EROSION AND STORMWATER QUALITY CONTROL PERMIT (ESQCP) EL PASO COUNTY APPLICATION AND PERMIT

Project Specifications	
Project Name	Woodford Manufacturing Co
Legal Description	Lots 1, BLK 1, Waynoka Road Industrial
Address (or nearest major cross streets)	2121 Waynoka Rd. Colorado Springs, CO 80915
Acreage (total and disturbed)	Total: 8.92 acres Disturbed: 8.92 acres
Schedule	Start of Construction: Fall 2018 Completion of Construction: Fall 2019 Final Stabilization: Fall 2019
Project Purpose	To develop site per plans
Description of Project	Proposing to build 18,000 s.f., addition used for Manufacturing & Warehouse complete with required parking and drive aisles.
Tax Schedule Number	54062-05-001

C1.1

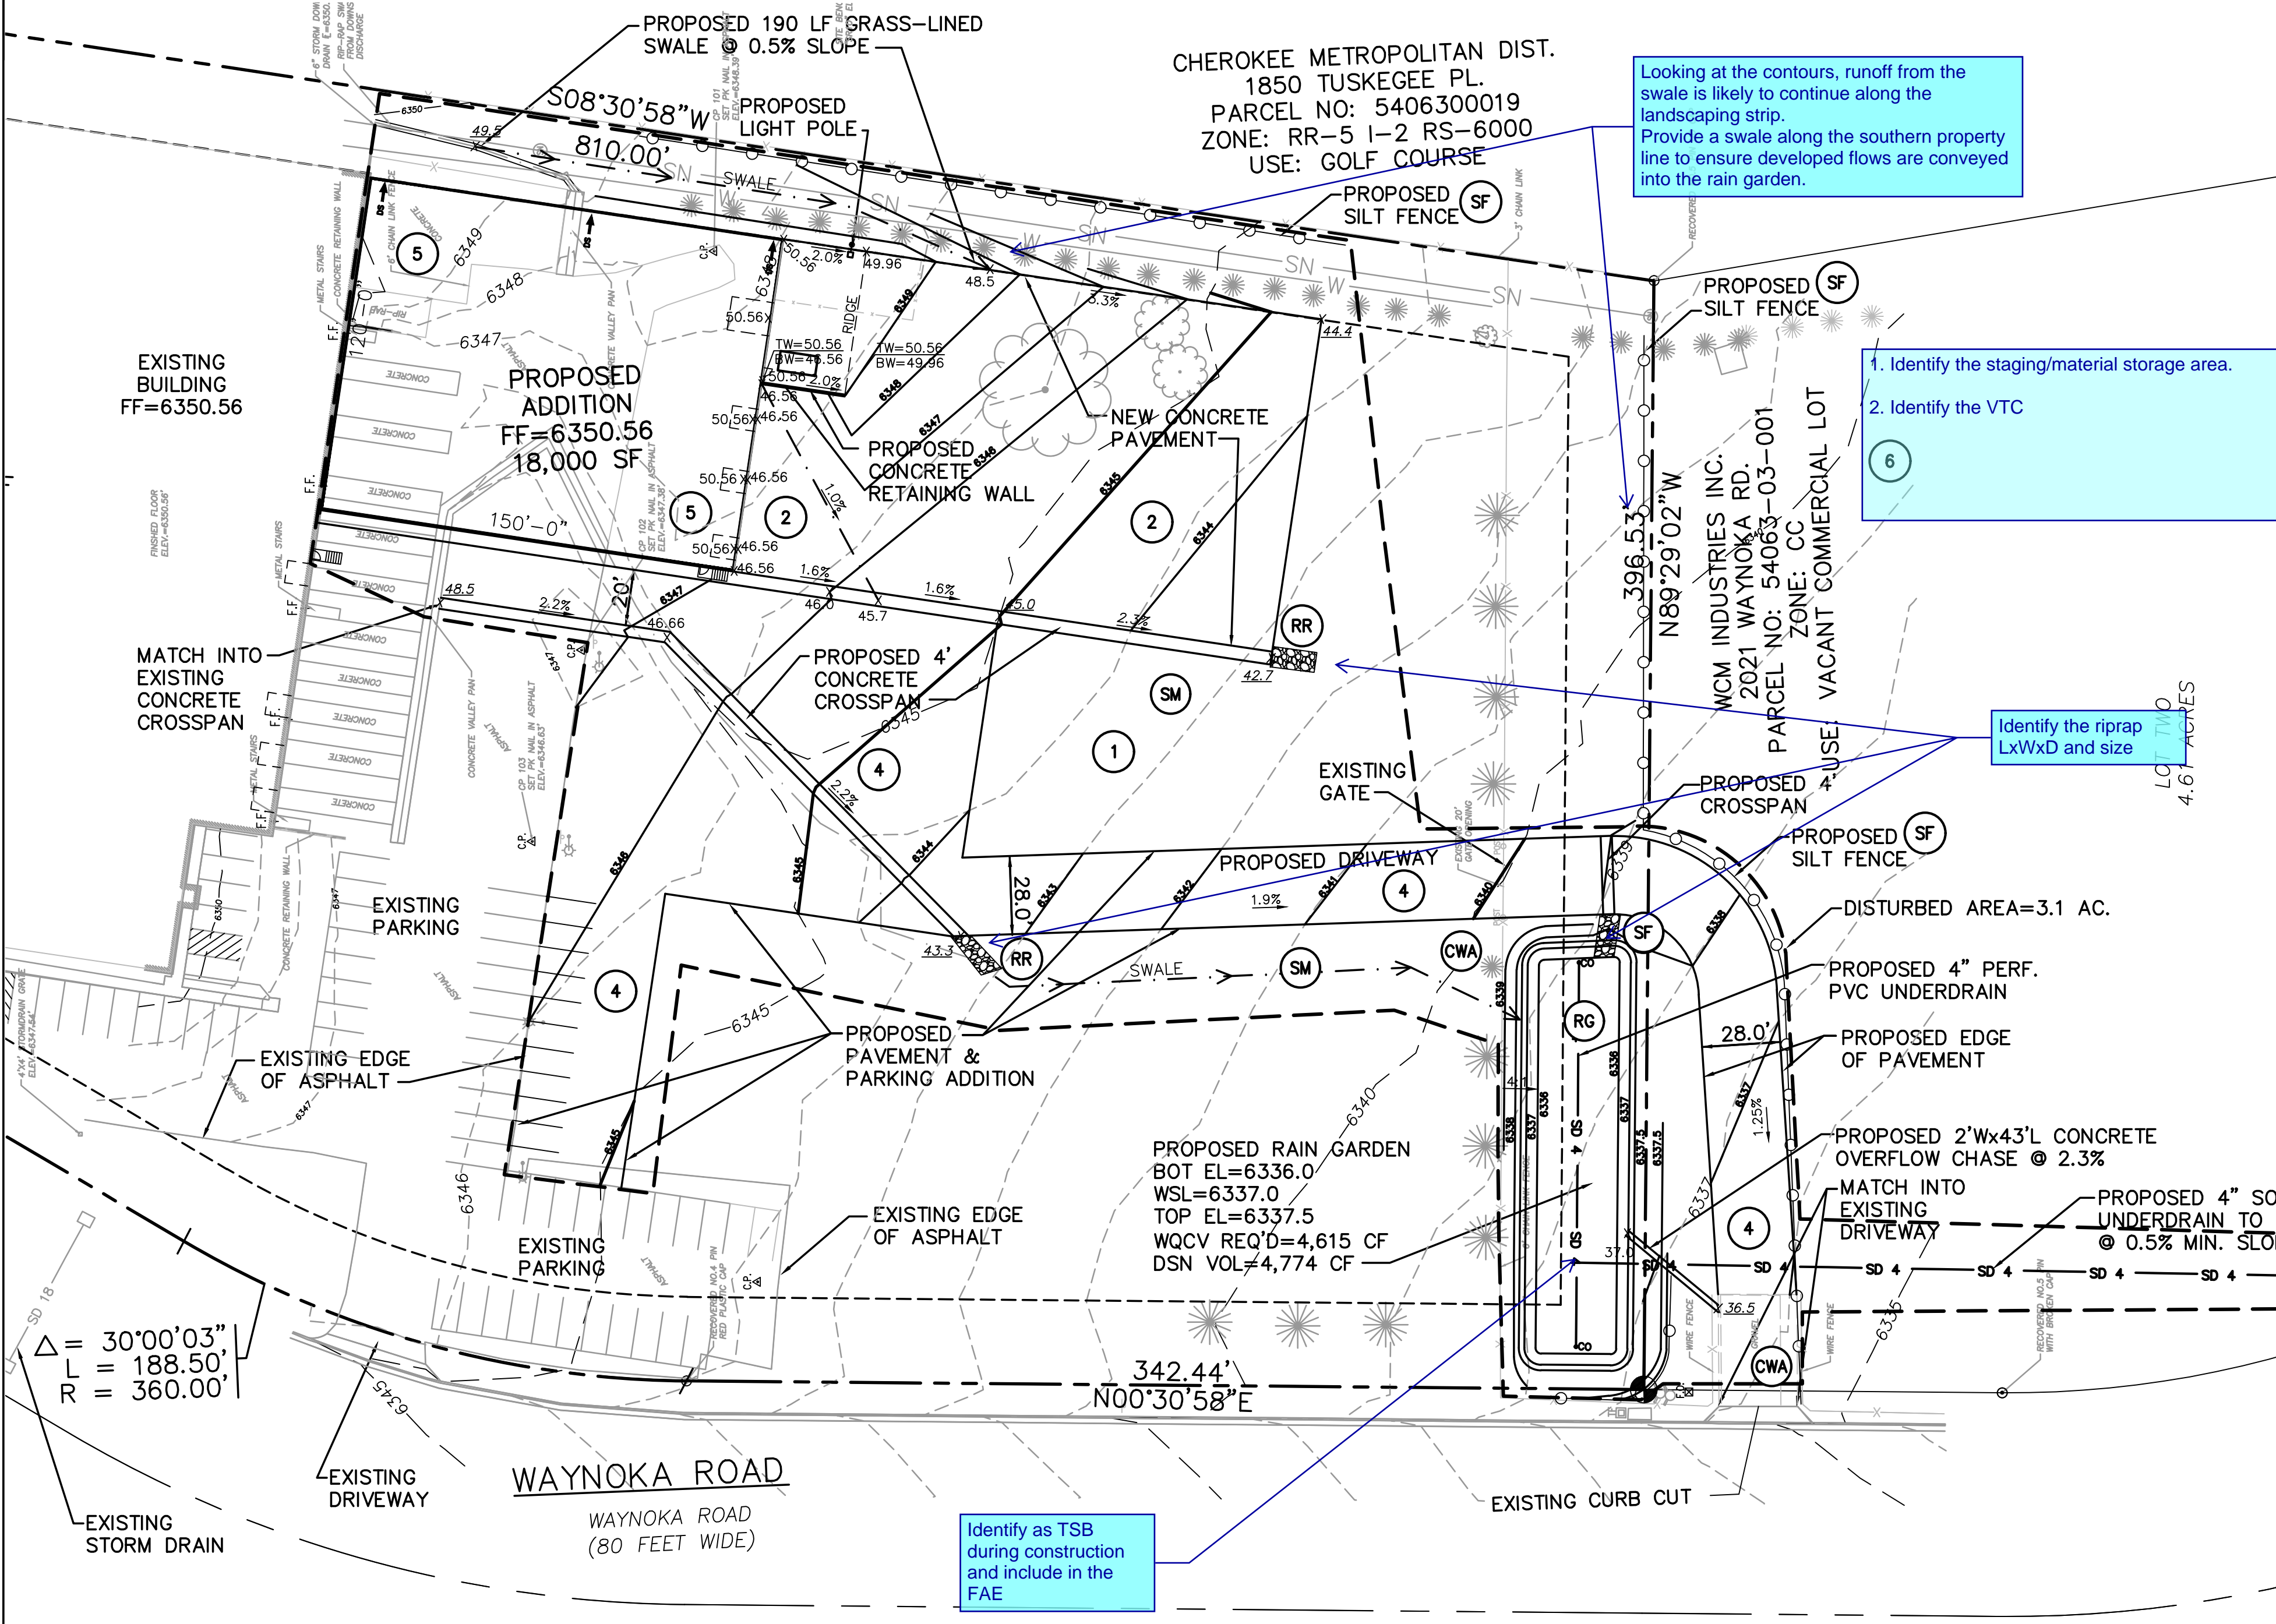
Update so the ESQCP, drainage letter and grading and erosion control plan all have the same value for the total disturbed area.
